**RE: Coordinated Vision, Inc  
Grading and Drainage Plan  
Engineer's Stamp Date 6-21-2016 (File:D16D002G)**

Based upon the information provided in your submittal received 6-27-2016, the above referenced Grading and Drainage Plan is approved for ESC Building Permit and for SO-19 Permit with the following condition:

C101

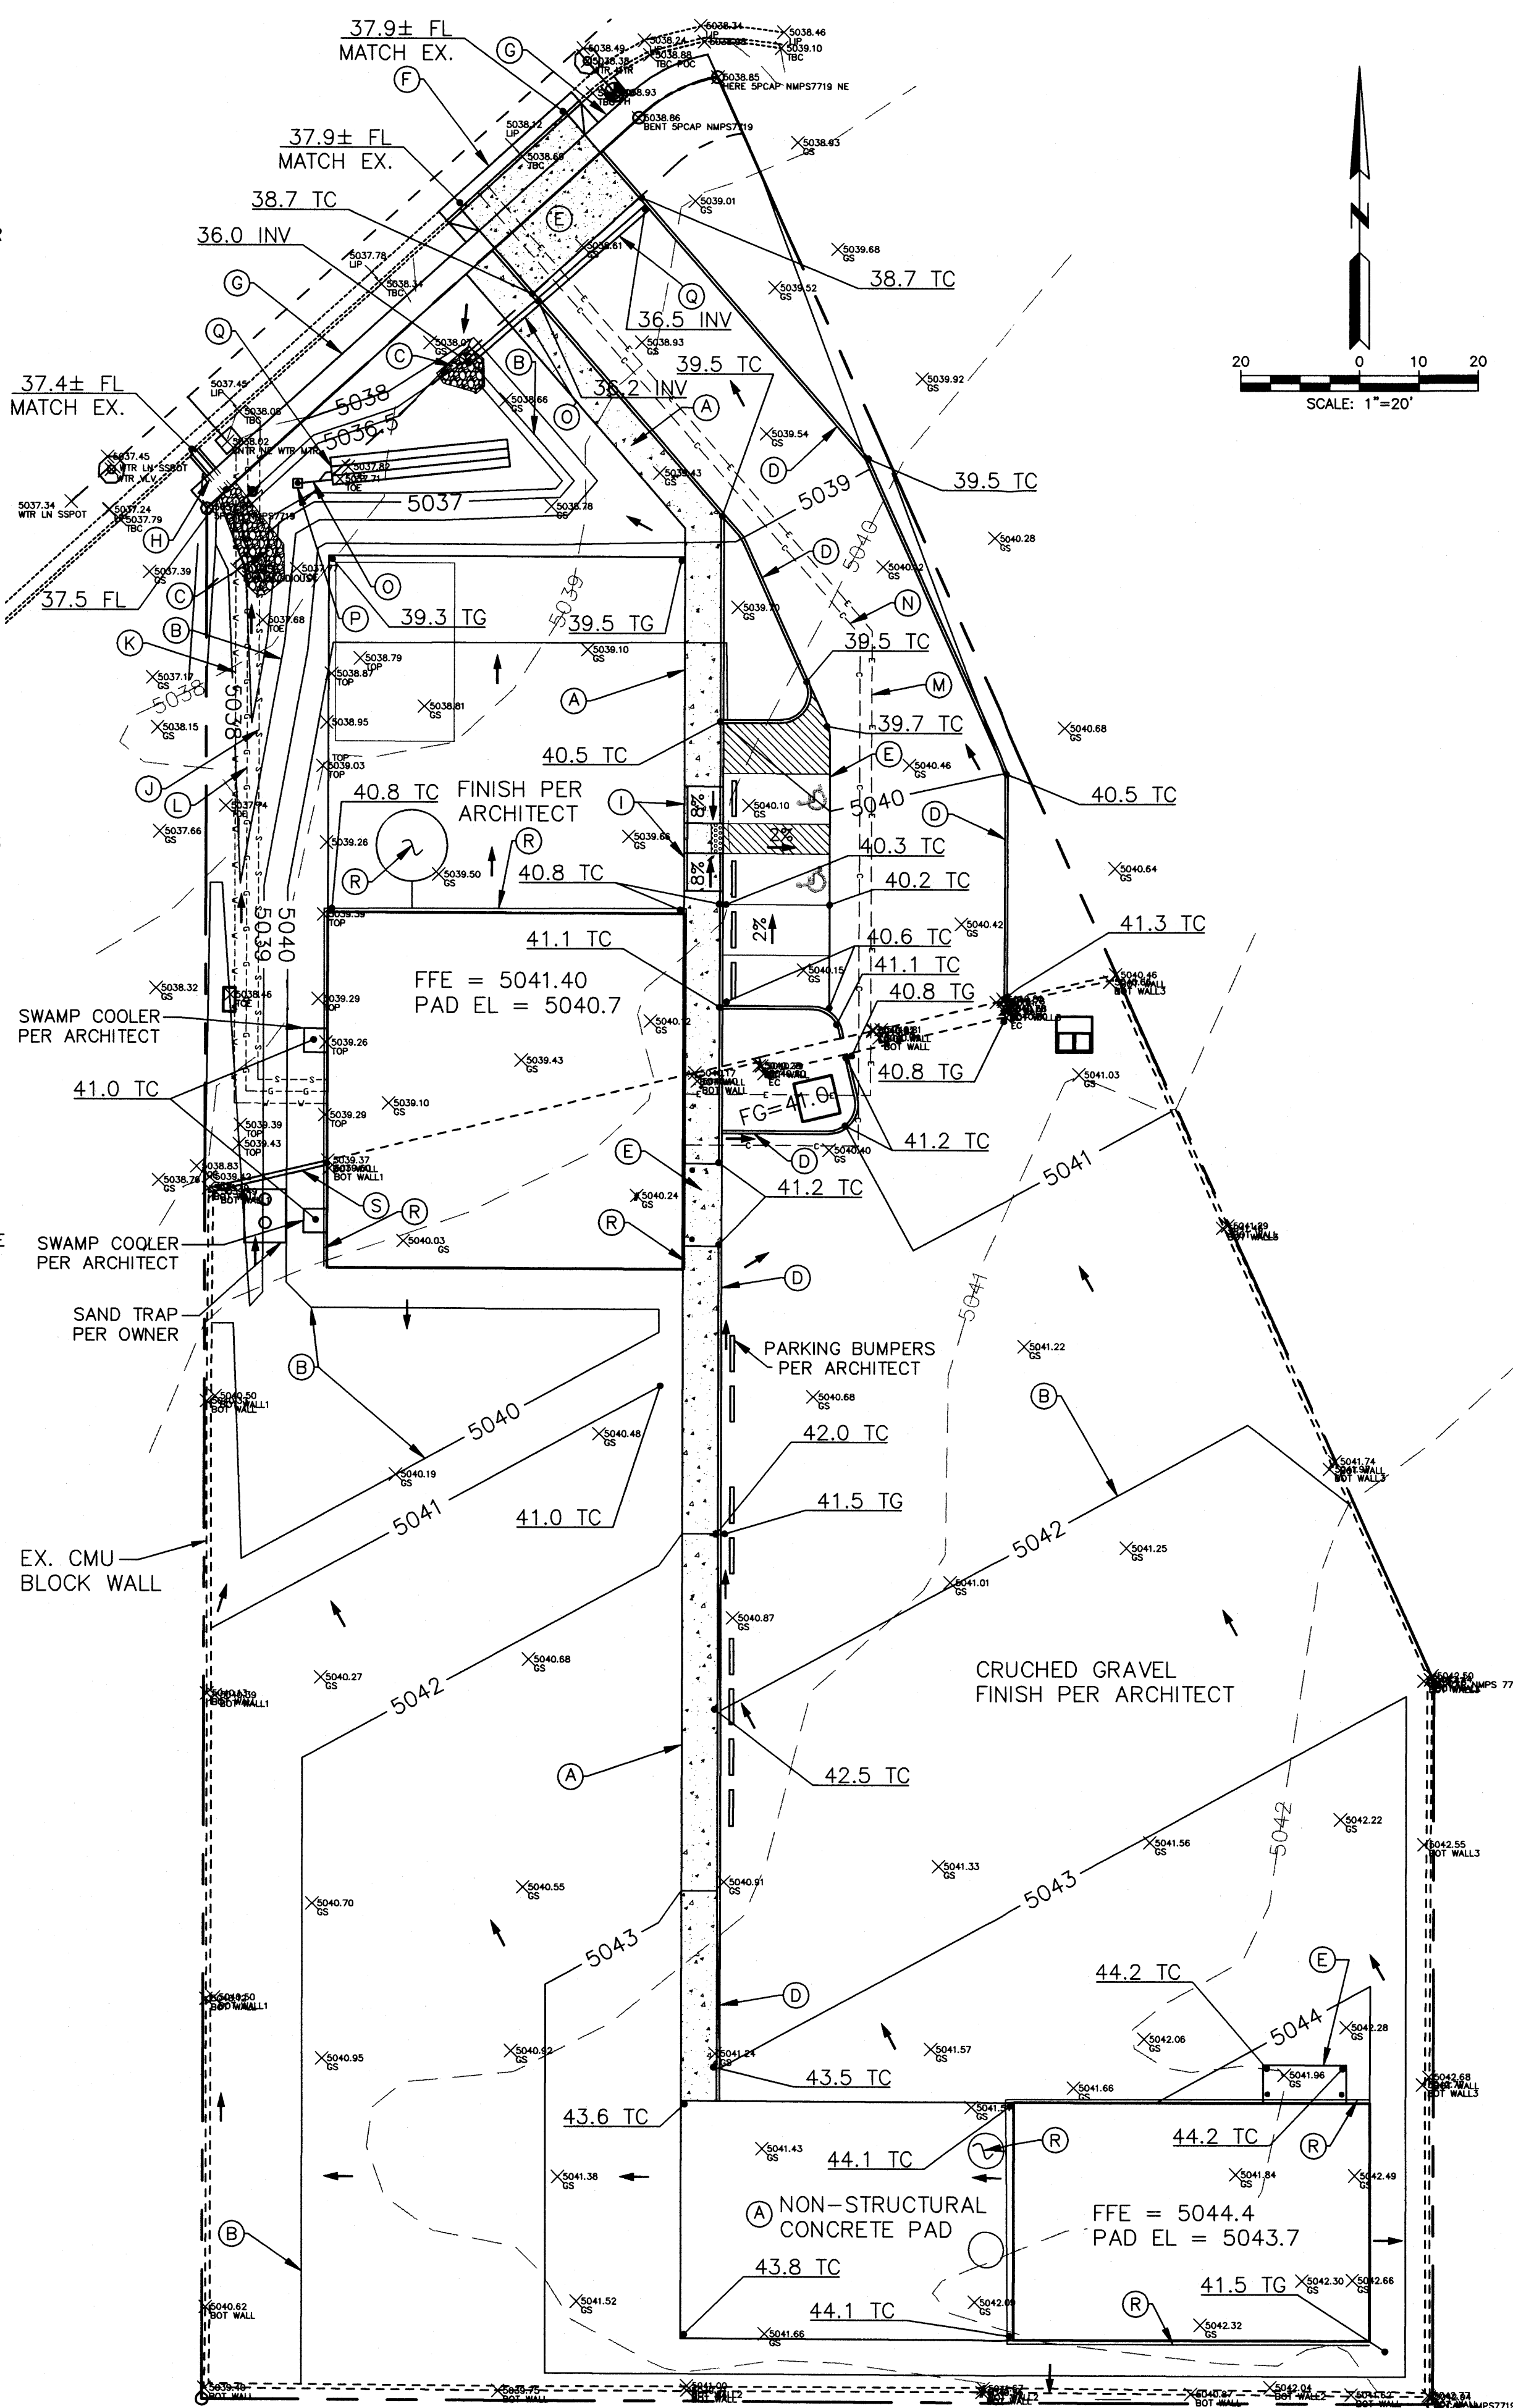
- The construction of the sidewalk in the Right of Way must include a depressed landscape buffer as shown on the revised Standard Drawings 2405A and B.
